Approval of details reserved by condition imposed under ref BN/50/20/PL relating to Condition Nos 5 - mitigation method statement, 6 - archaeology, 7 - piling risk assessment & method statement, 8 - Construction & Environmental Management Plan, 9 - foul drainage, 10 - surface water drainage, 11 - maintenance & management of surface water drainage, 13 - pre-commencement site meeting, 15 - odour assessment or evidence that livery has ceased, 16 - soil resource plan, 17 - landscaping, 18 - screen walls & fences, 19 - elevation details of 2 proposed communal bin stores and 20 - colour schedule of materials & finishes.

Land Rear Of 1 Northfields Cottages Fontwell Avenue Eastergate PO20 3RX

Notification regarding the above application:

LLD1544-ARB-DWG-002

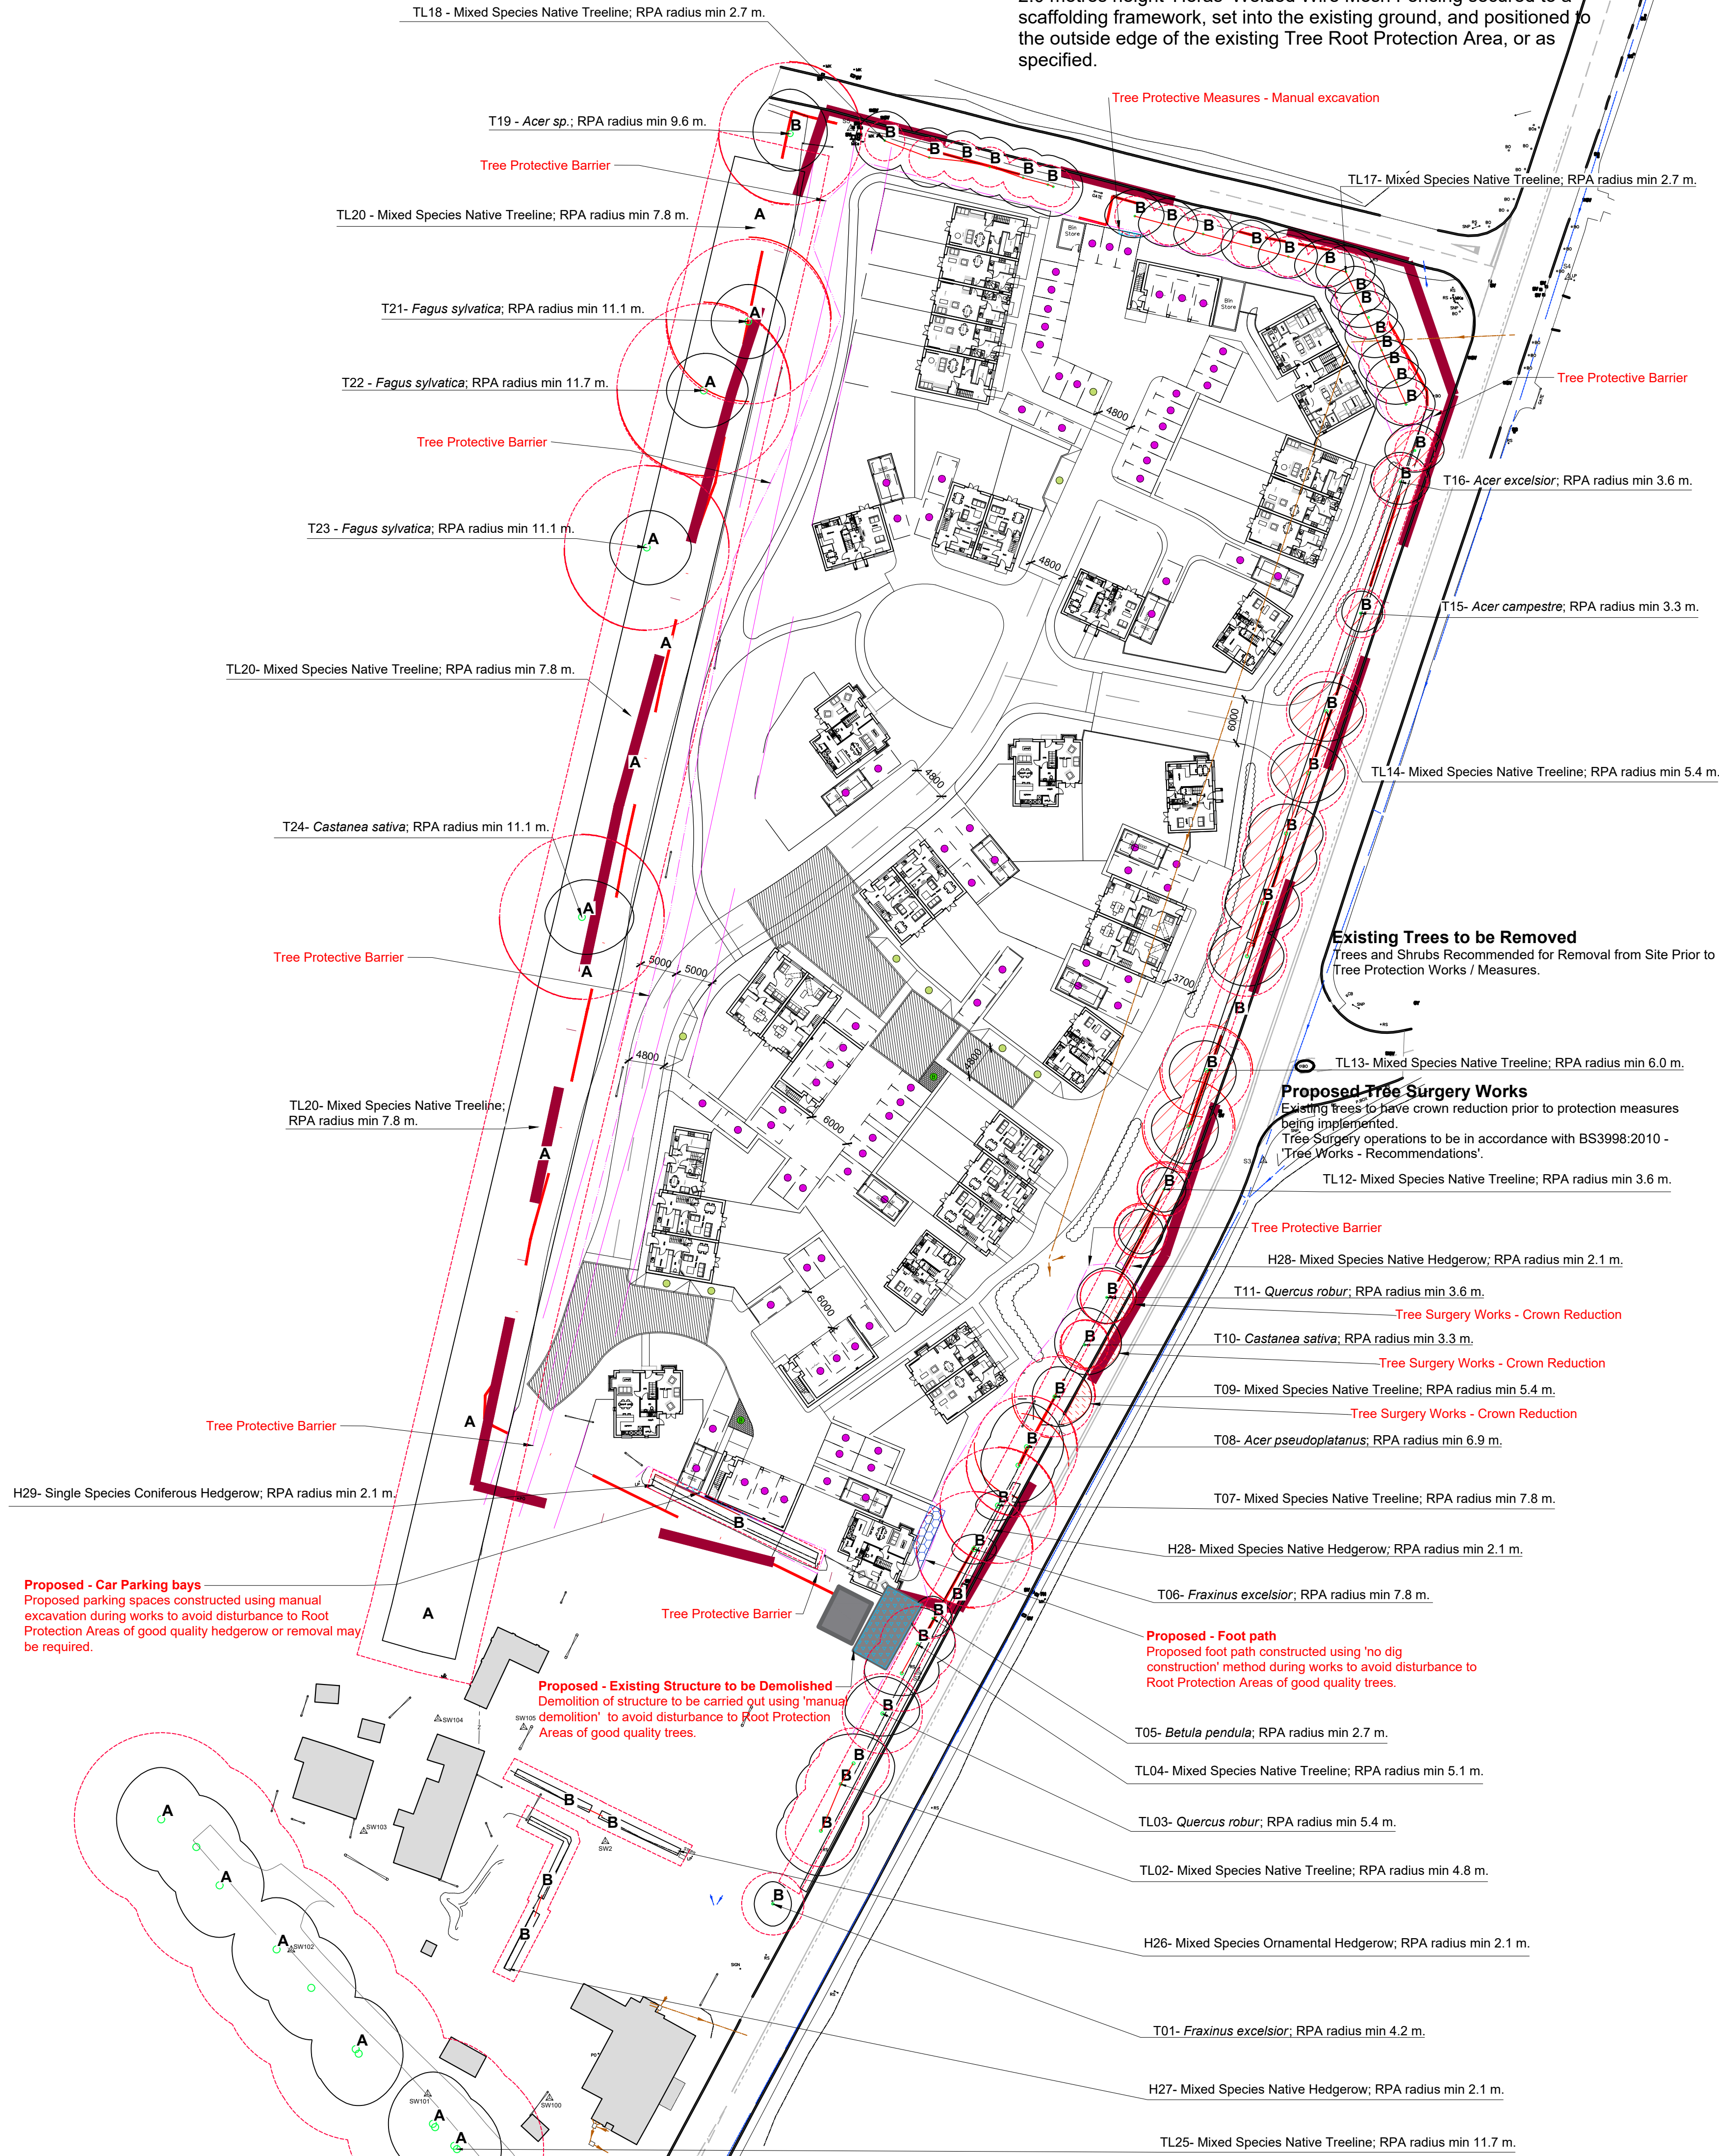
Arun District Council have decided to **REFUSE details reserved by condition for the following reasons:**
This condition requires a mitigation method statement to provide details of how those retained hedgerows are to be protected & enhanced and to show a 5m buffer zone around the retained hedges. I acknowledge that your drawing ref LLD1544-ARB-DWG-002-03-TRPP does show protective fencing

around the hedges but there is no mitigation method statement and so it is not clear how the other parts of the condition are met or indeed how the submission relates to the need to protect the hedges for bats.
